**KIRKLEES METROPOLITAN COUNCIL
INVESTMENT & REGENERATION SERVICE**

DELEGATED DECISION TO DETERMINE PLANNING APPLICATIONS

Reference No:	2025/62/90364/E
Site Address:	43, Daisy Hill, Dewsbury, WF13 1LF
Description:	Alterations to convert retail unit to one residential unit (within a Conservation Area)
Recommending Officer:	Nina Sayers

DECISION - Refuse

Issue Purpose : Full Application		
Project	Proposed change of use of ground floor to one bedroom flat	Date 28-01-2025
		Scale 1:100 @ A3
Address	43 Daisy Hill, Dewsbury, WF13 1LH	Ex and pr Elevations
		D.N. 2025 - 43DH - 03

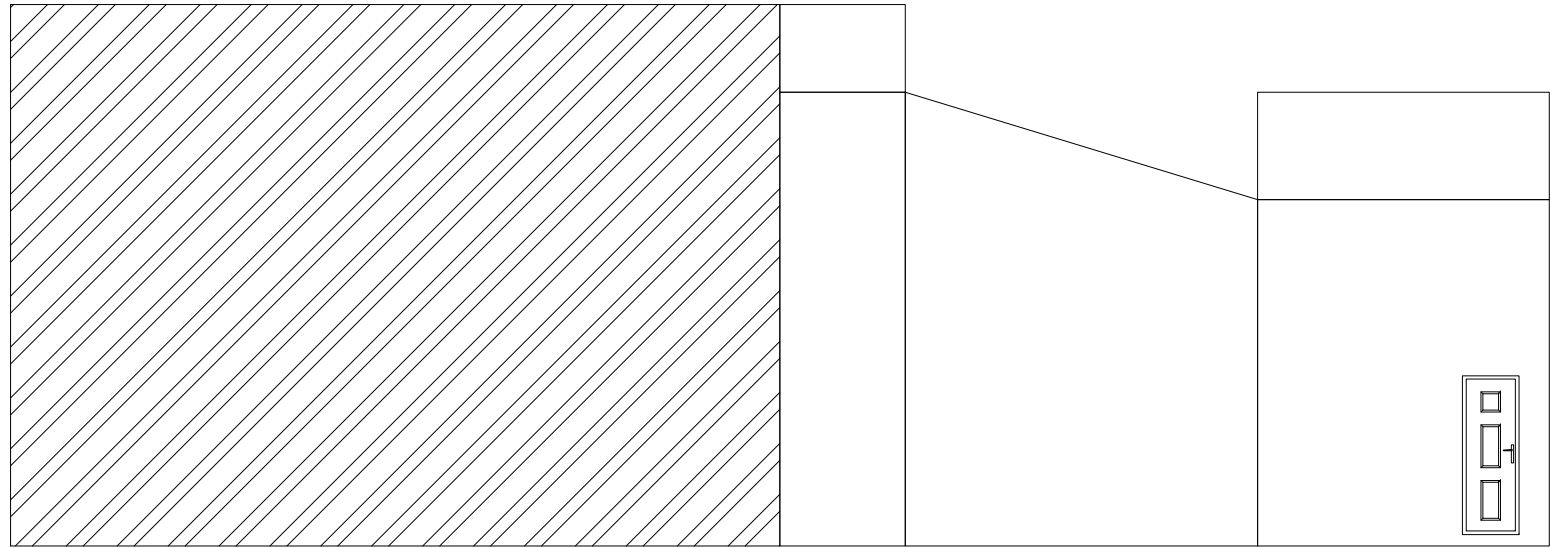
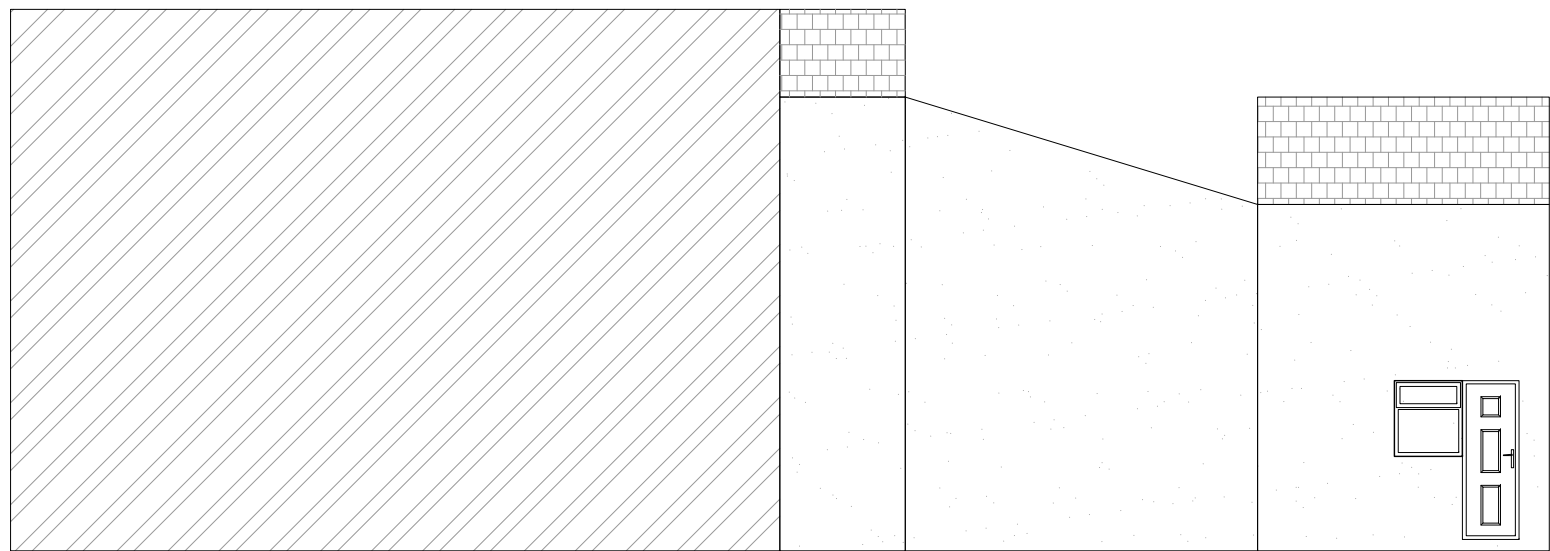
The proposal would include the removal of the shop frontage and fascia and would replace it with a window and doorway. An additional window would also be installed in the side elevation. No details of window sills or lintels have been proposed and to ensure this is in keeping with the historic character of the conservation area, details are recommended to be secured via condition should this application be approved.

Visually, the shop front forms a key part of Daisy Hill and Dewsbury Town Centre and as such from a visual amenity perspective it would be preferred that the retail unit is retained however this is not considered to be a reason to refuse the application on its own.

It is also noted that the proposed flat is only served by one window to the front which serves the open plan living and bedroom space and one small window to the rear which serves the kitchen. Given the shape of the proposed flat, this is considered to provide insufficient natural light and outlook for the future occupants, particularly when considering that due to the overlooking harm discussed above, any future occupant is likely to prefer the window at least partially obscured.
